Referral Point : Claire Potts / Planning Officer – seeking advice on an application for approval of reserved matters relating to tree protection.

Reference : LU/234/16/RES

Location : Land between the A259 Worthing Road and the East Street/Fitzalan Road roundabout

TPP.6

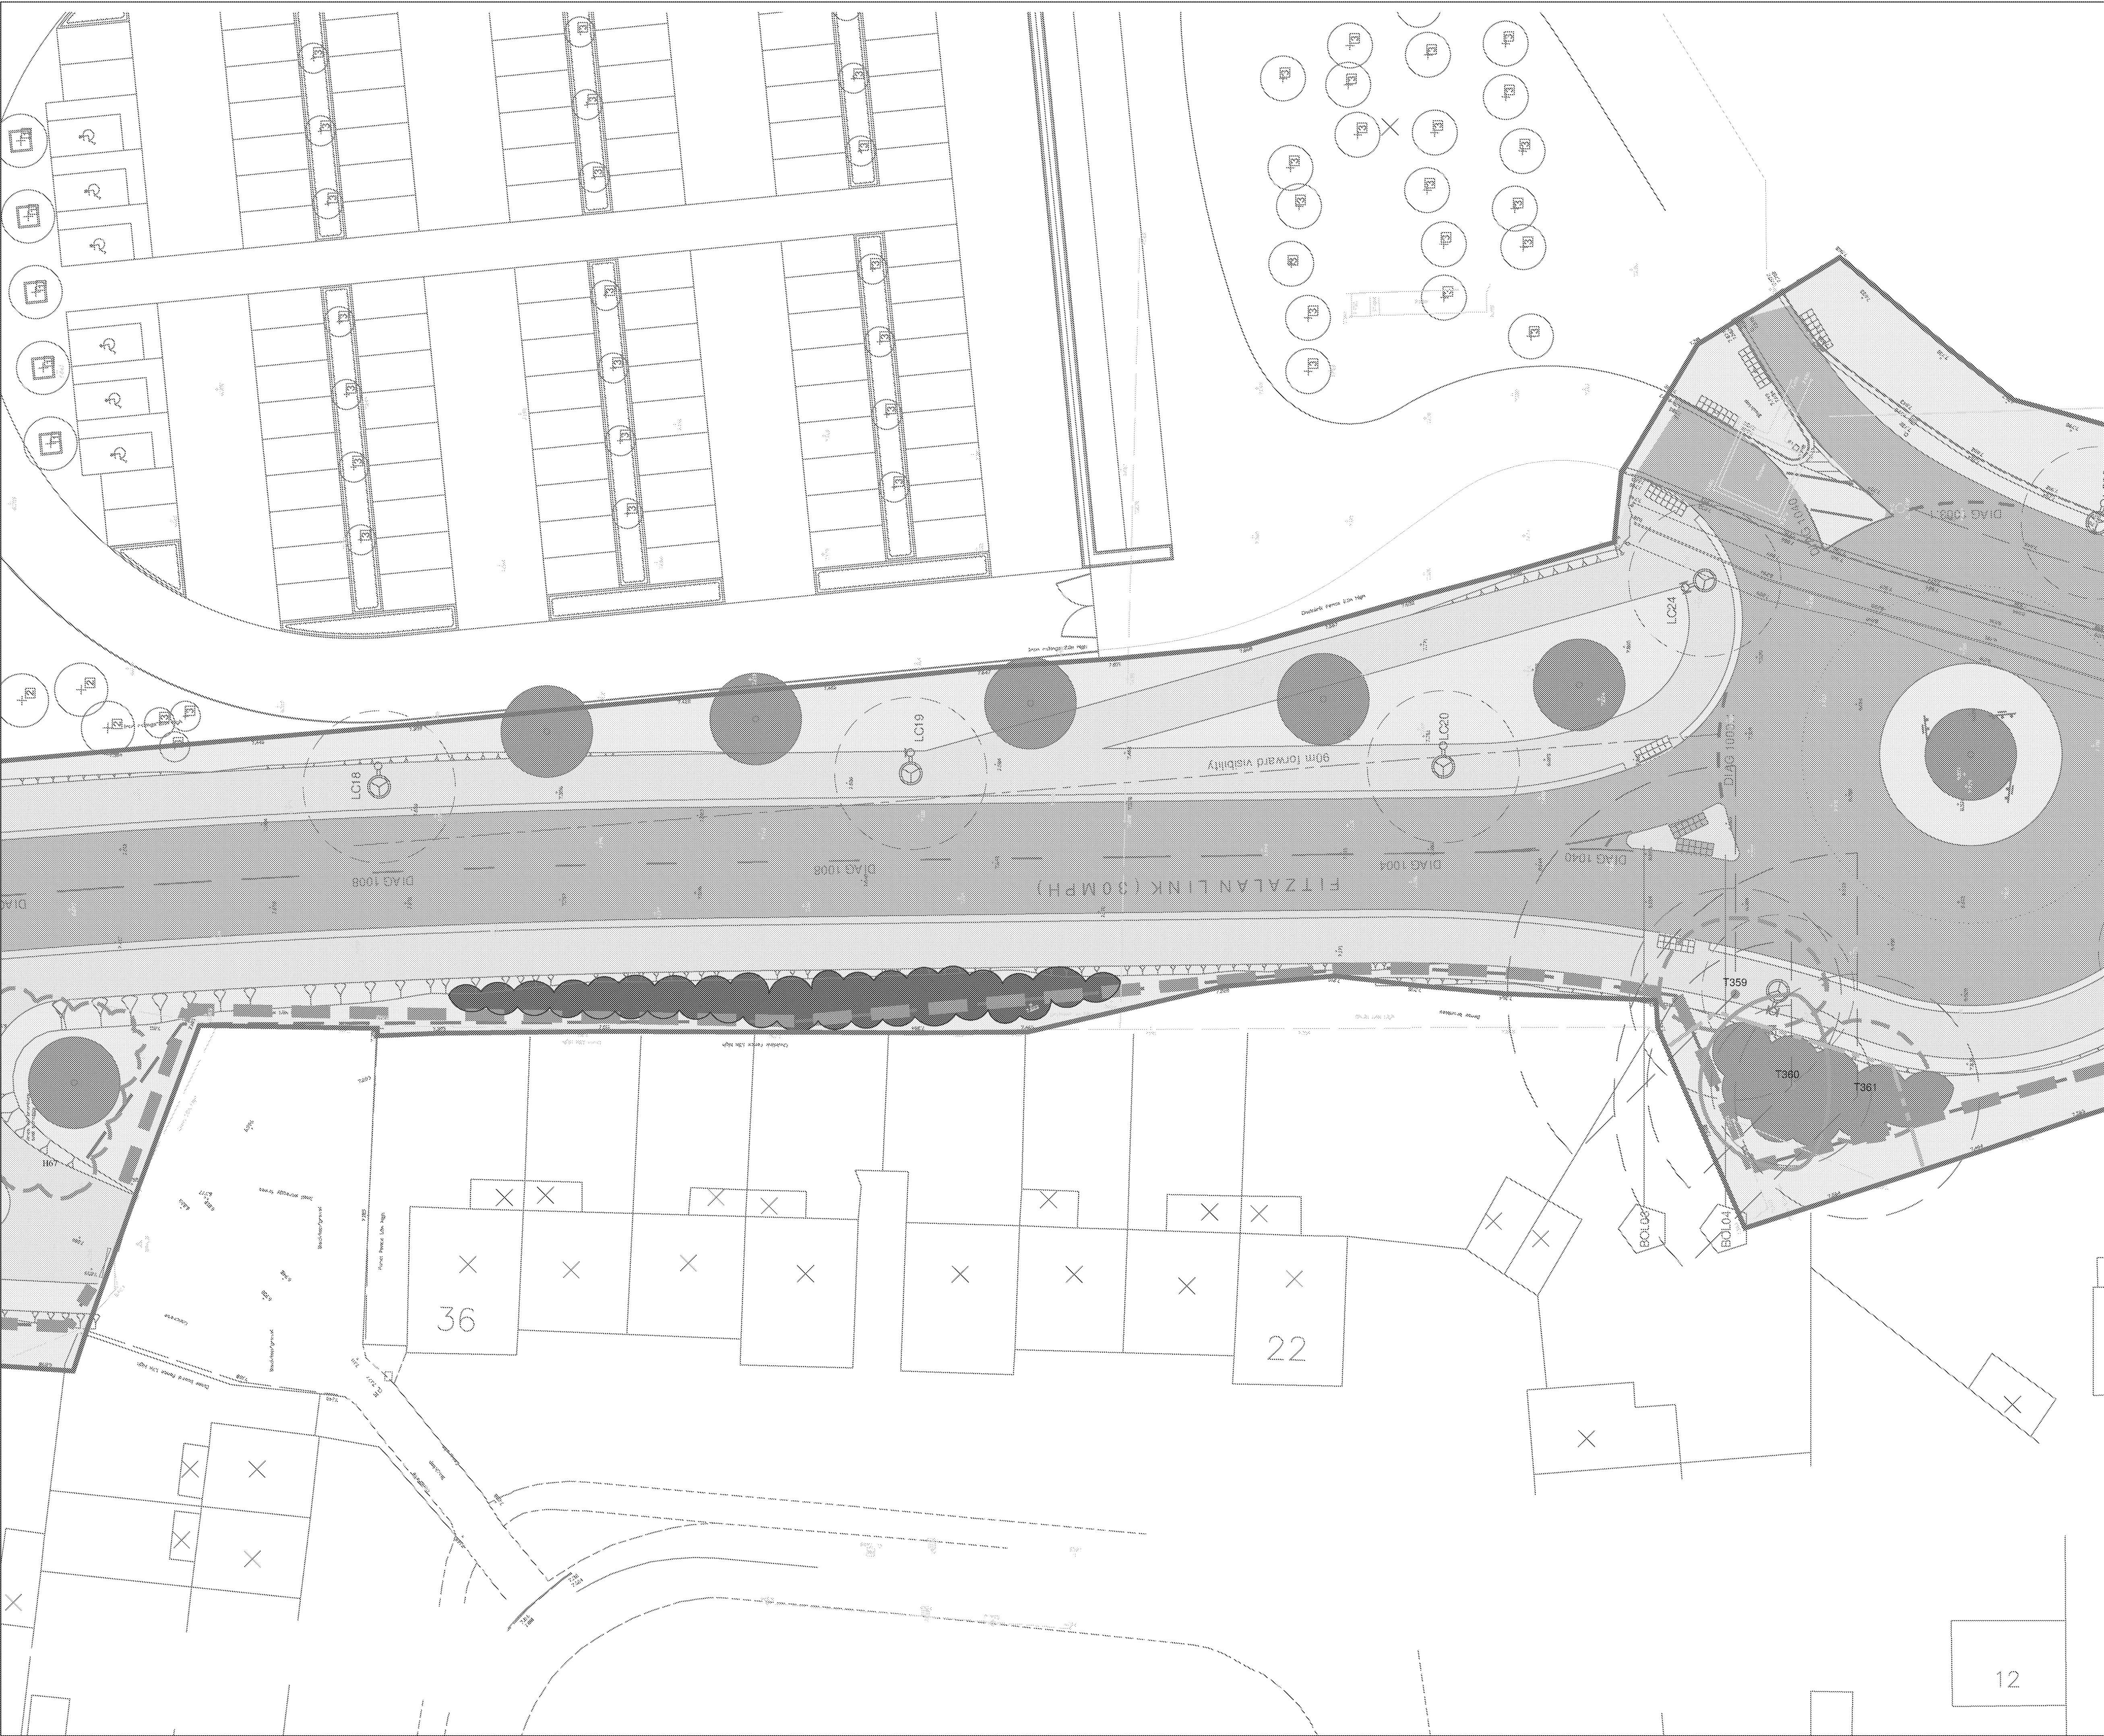
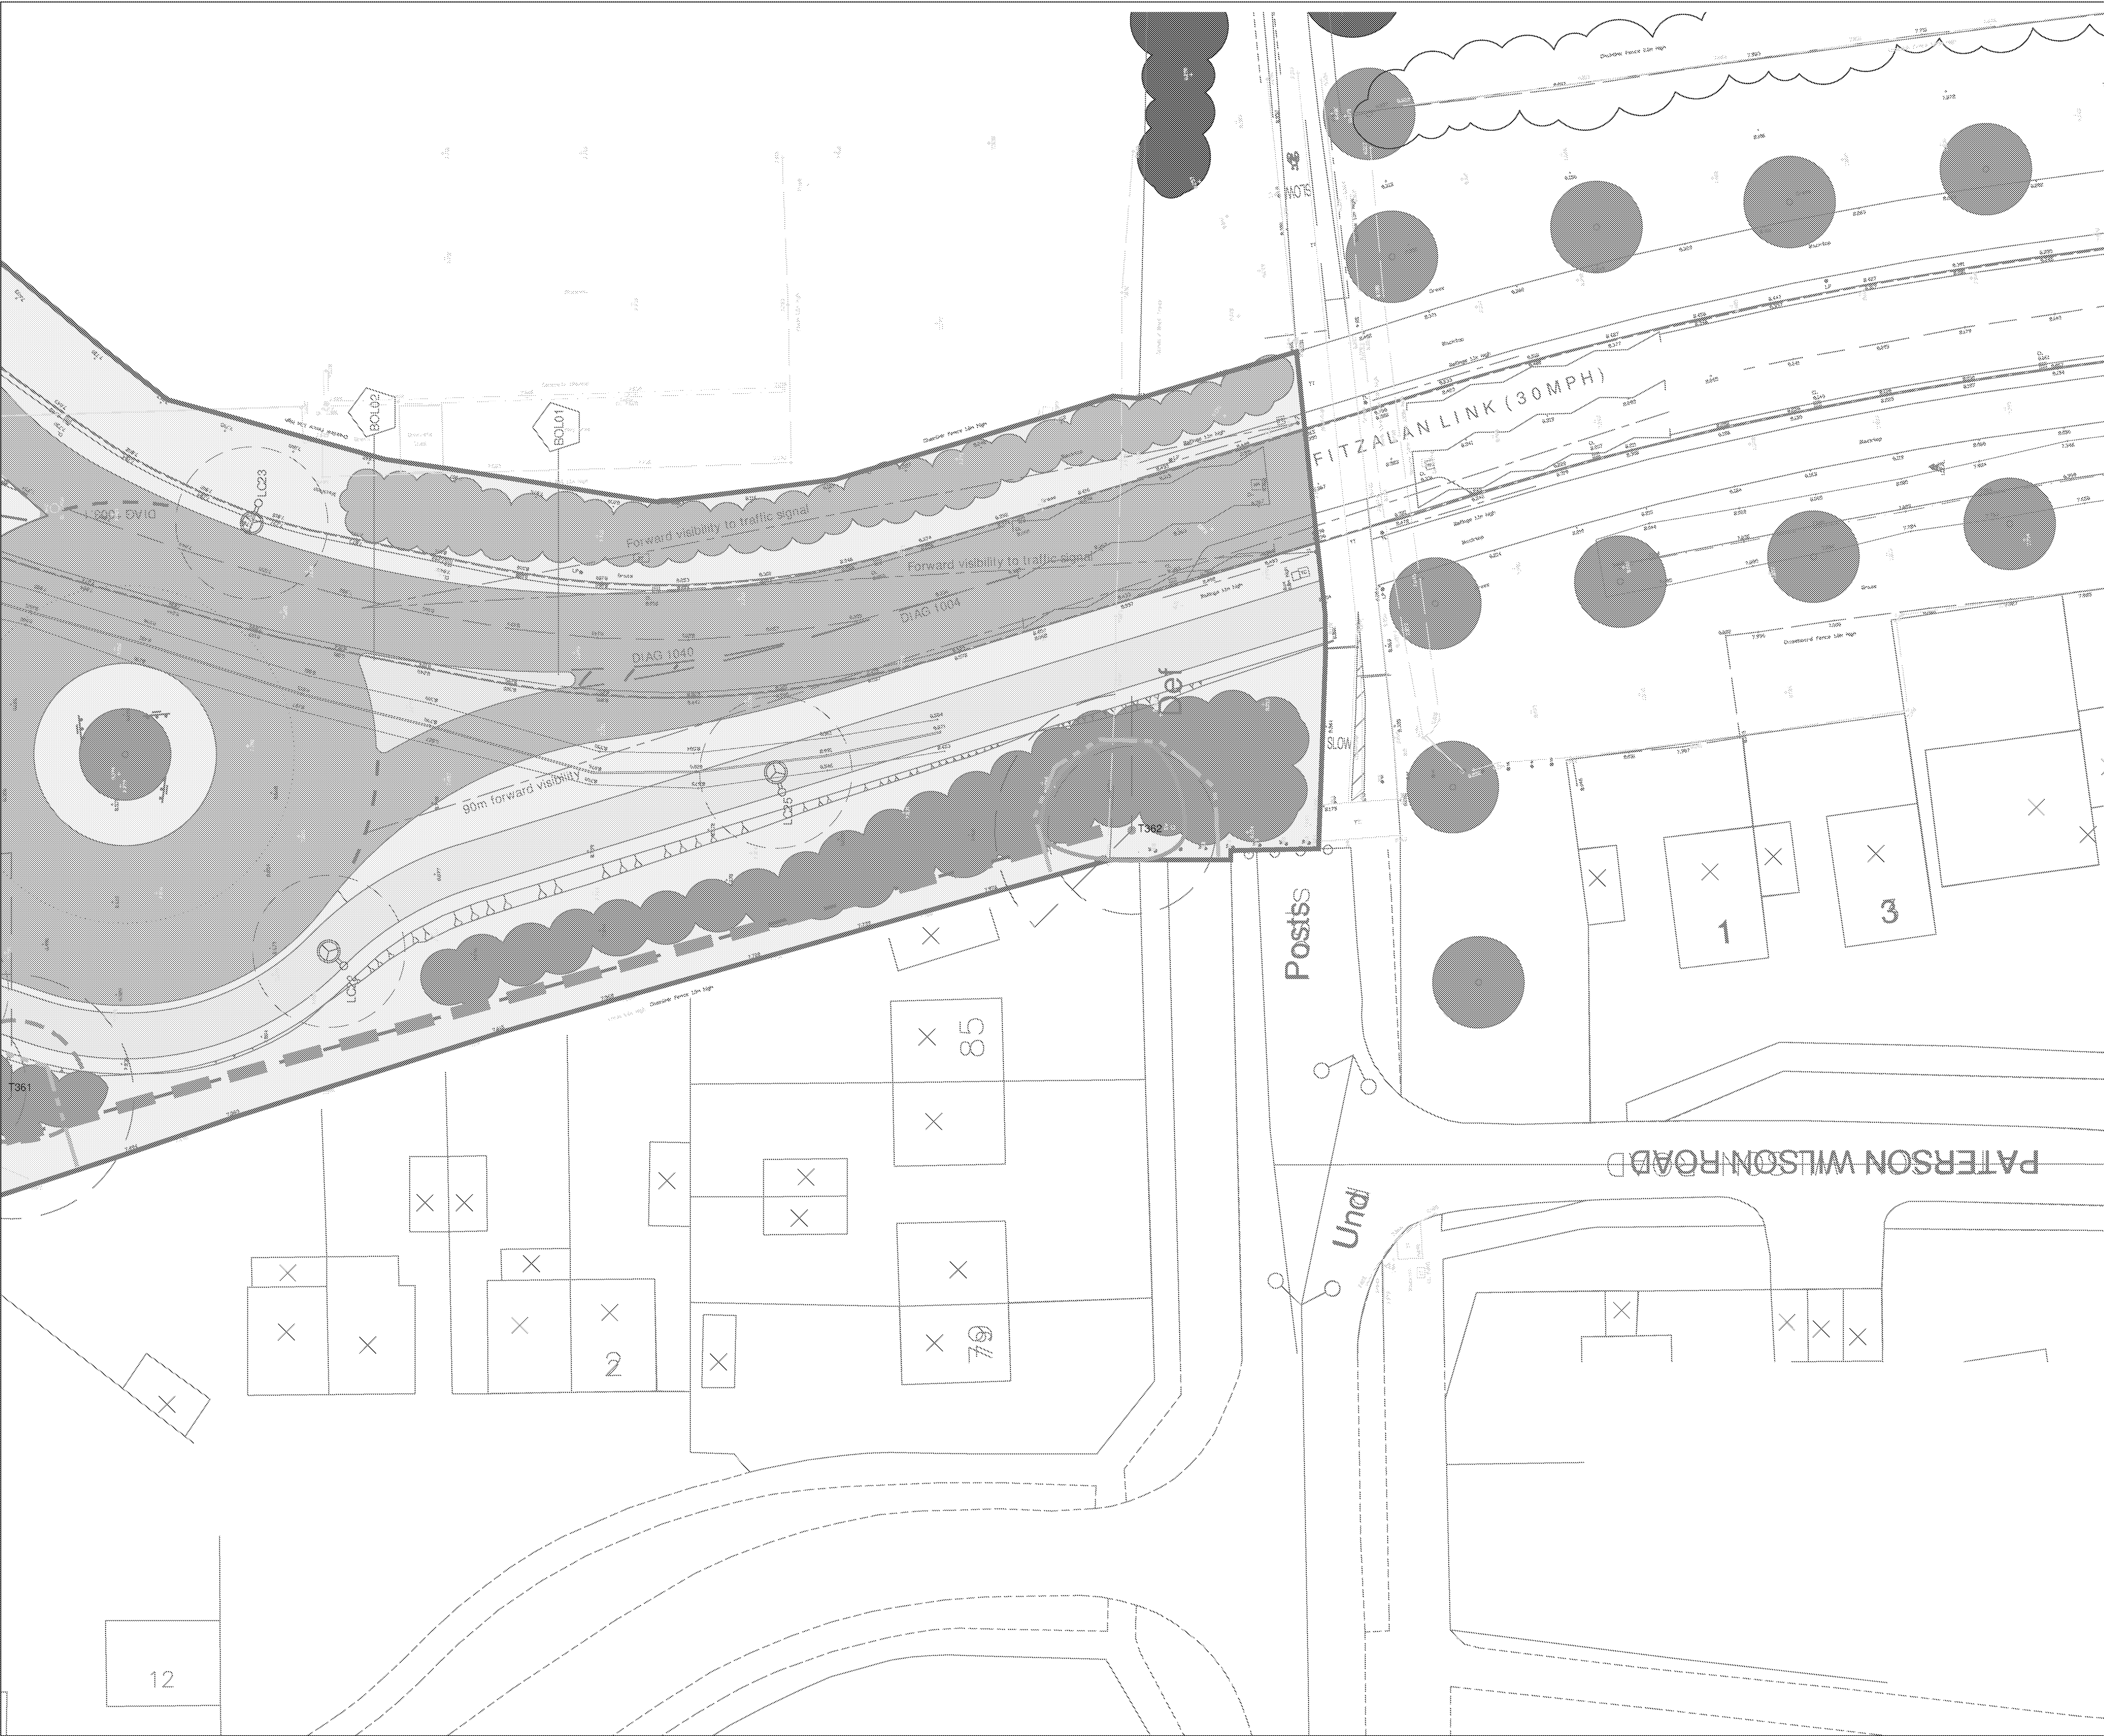
- I walked the route and noted that there are little or no trees or vegetation alongside the western boundary with existing residential development.
- There is however quite a lot of mature and maturing Lombardy Poplars/Hybrid Poplars and Ash trees alongside the eastern boundary with the Academy School grounds which are trees we would wish to see retained and fully protected during the development process.

- These plans show that a full and detailed tree survey and root protection schedule exercise has been undertaken and that protective fencing requirements have been calculated and plotted on the Landscape Plans.

I am happy with the level of Arboricultural input in respect of plans submitted and the levels of tree protection shown will be adequate to ensure that these trees are all retained in a sound and healthy state. Provided that the protective fencing is to Section 6 & Figure 2 standards as prescribed within BS5837:2012.
